# PORTLAND MAINE

September 27, 2007

RE: 133-135 Commonwealth Drive – 300 F011 – R-3 – build a detached garage – Permit #07-1181

to sidewalk.
135 EAST COMMONWEALTH DRIVE

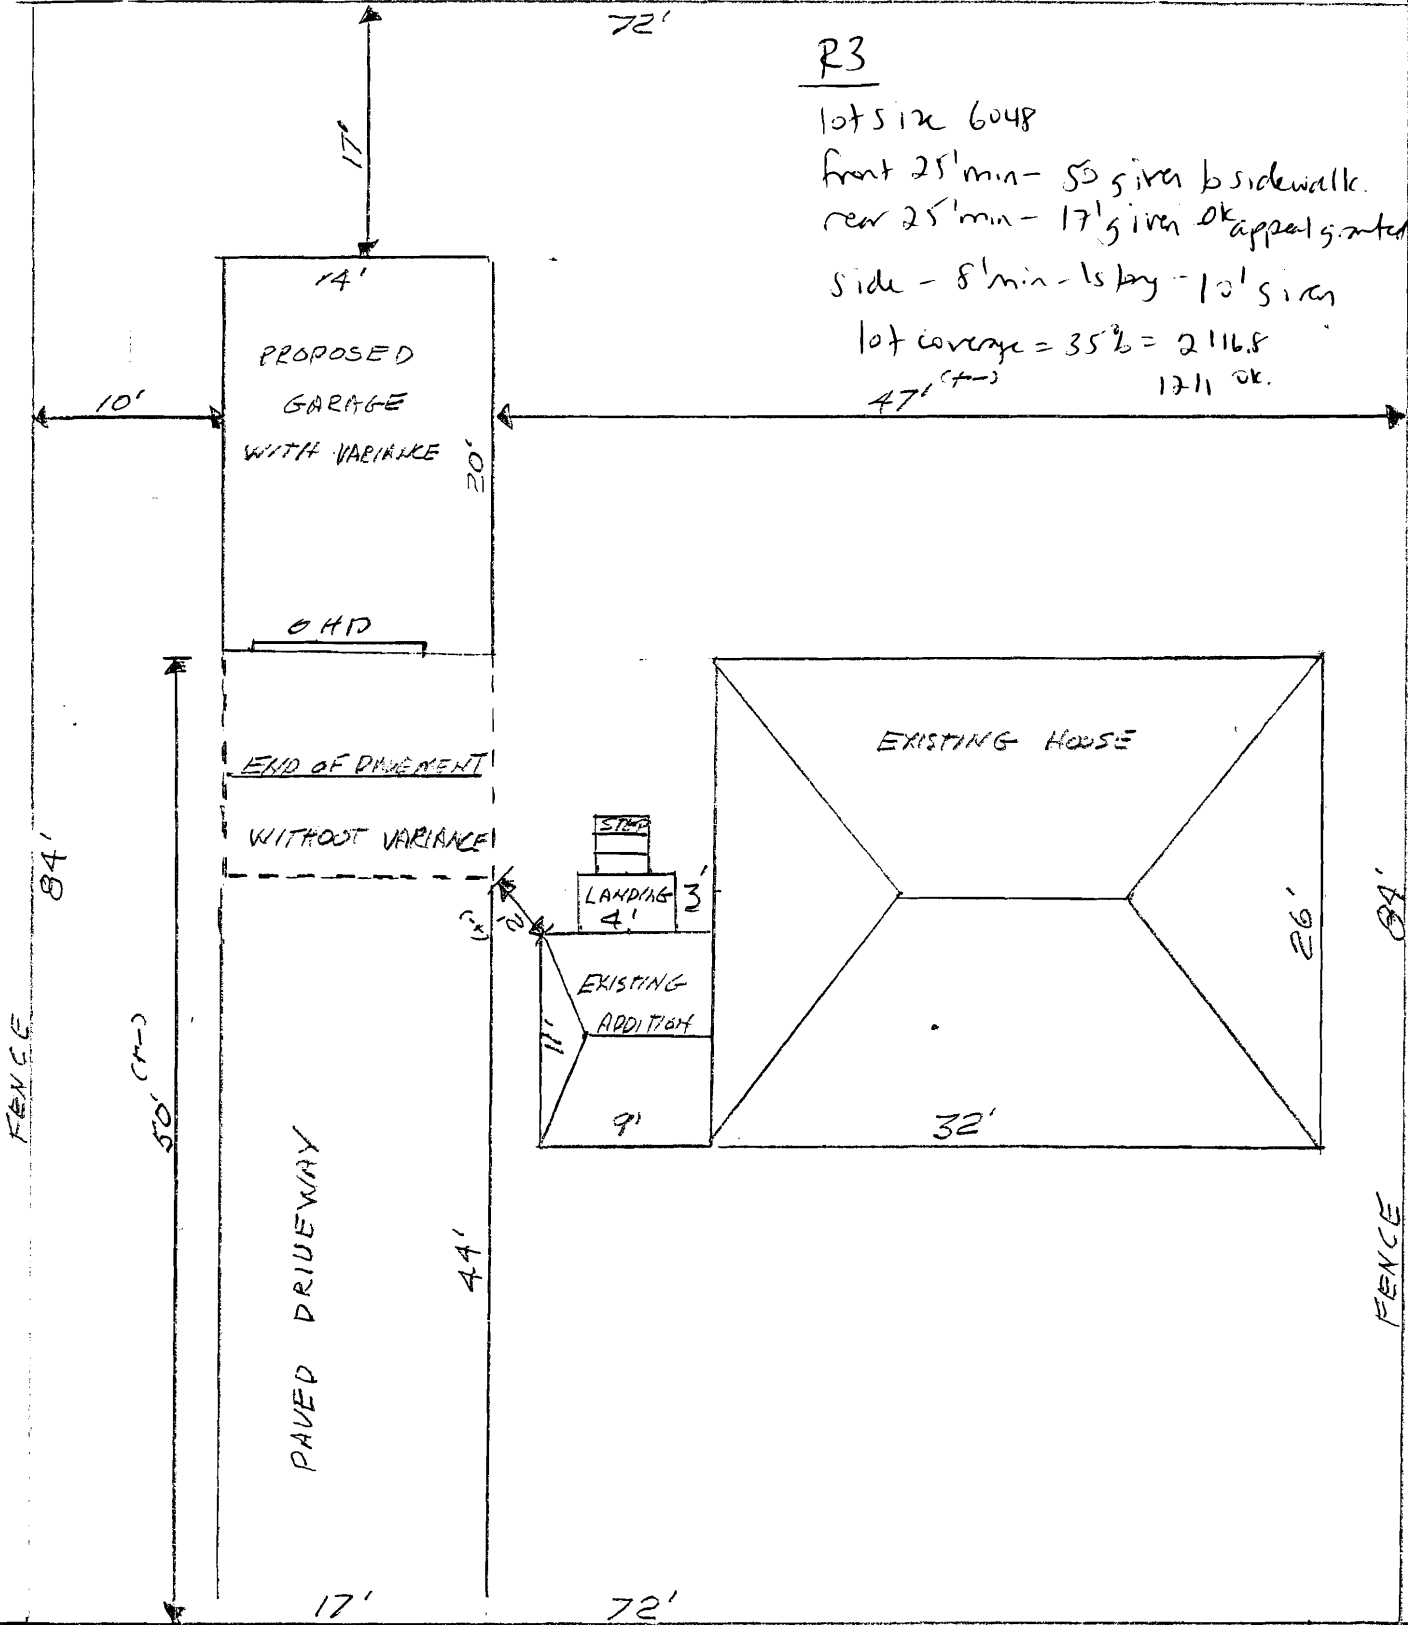
I am in receipt of your application to build a fourteen by twenty foot detached garage at your property at 133-135 Commonwealth Drive. In reviewing your application, it has come to my attention that the proposed garage does not meet the required rear setback. Your property is located in the R-3 residential zone. Section 14-90(d)(2) of the ordinance states that the rear setback is twenty-five feet. The plot plan that was submitted with your application shows the rear setback to the proposed structure is nineteen feet. Since the setback to the proposed garage does not meet the minimum required setback of twenty-five feet, I must deny your application to build the garage.
